PR 234 Schubert Ranch Sand Resource

1/30/2024

Grading and Erosion Control Plan Checklist, Response to Comments:

EPC Project Number: PPR234

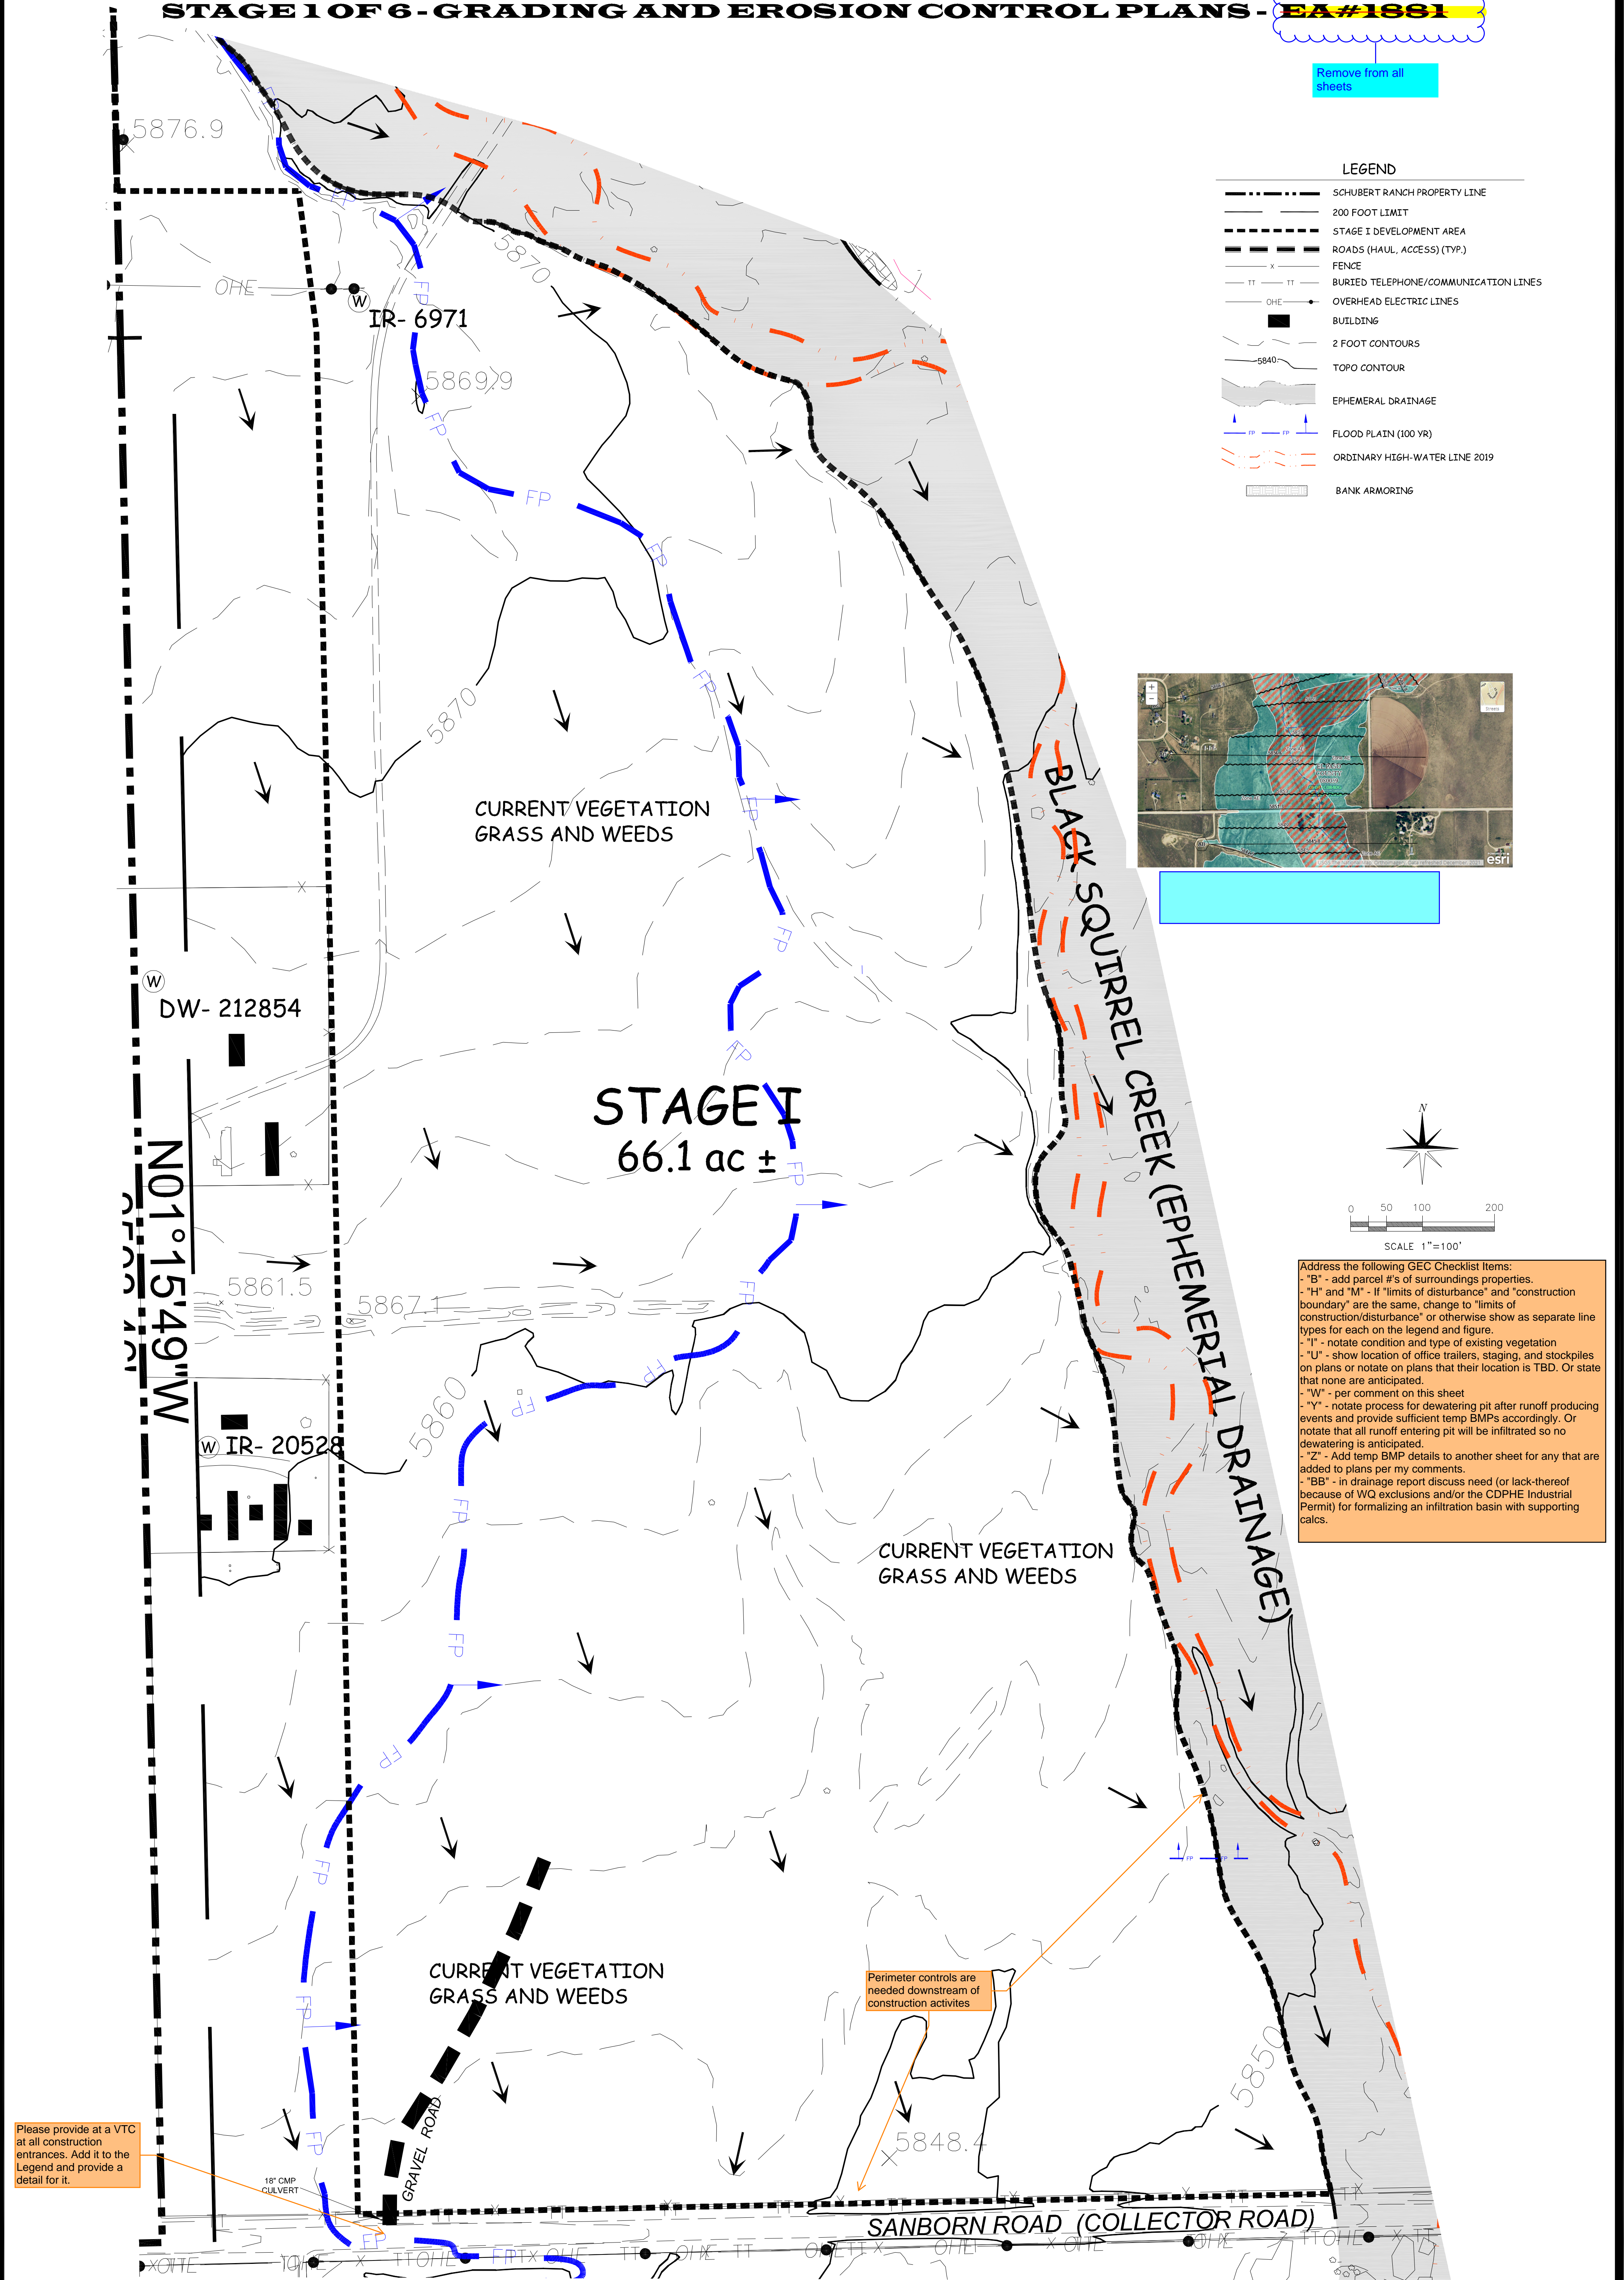
1. PPR 234 has been added to all pages.
 2. Applicant column has been completed.
 - z. We do not plan or anticipate the need for temporary construction control measures.
 - cc. There are no existing or proposed easements. There are no affected off-site easements of which we are aware.
 - dd. No retaining walls are planned.
 2. a-k Please see checklist.
 - 3.28 The requested information has been placed on Sheet 1, GEC Plan.
- Just FYI - Silt fence is a temporary construction control measure, which is shown on the GEC Plan.
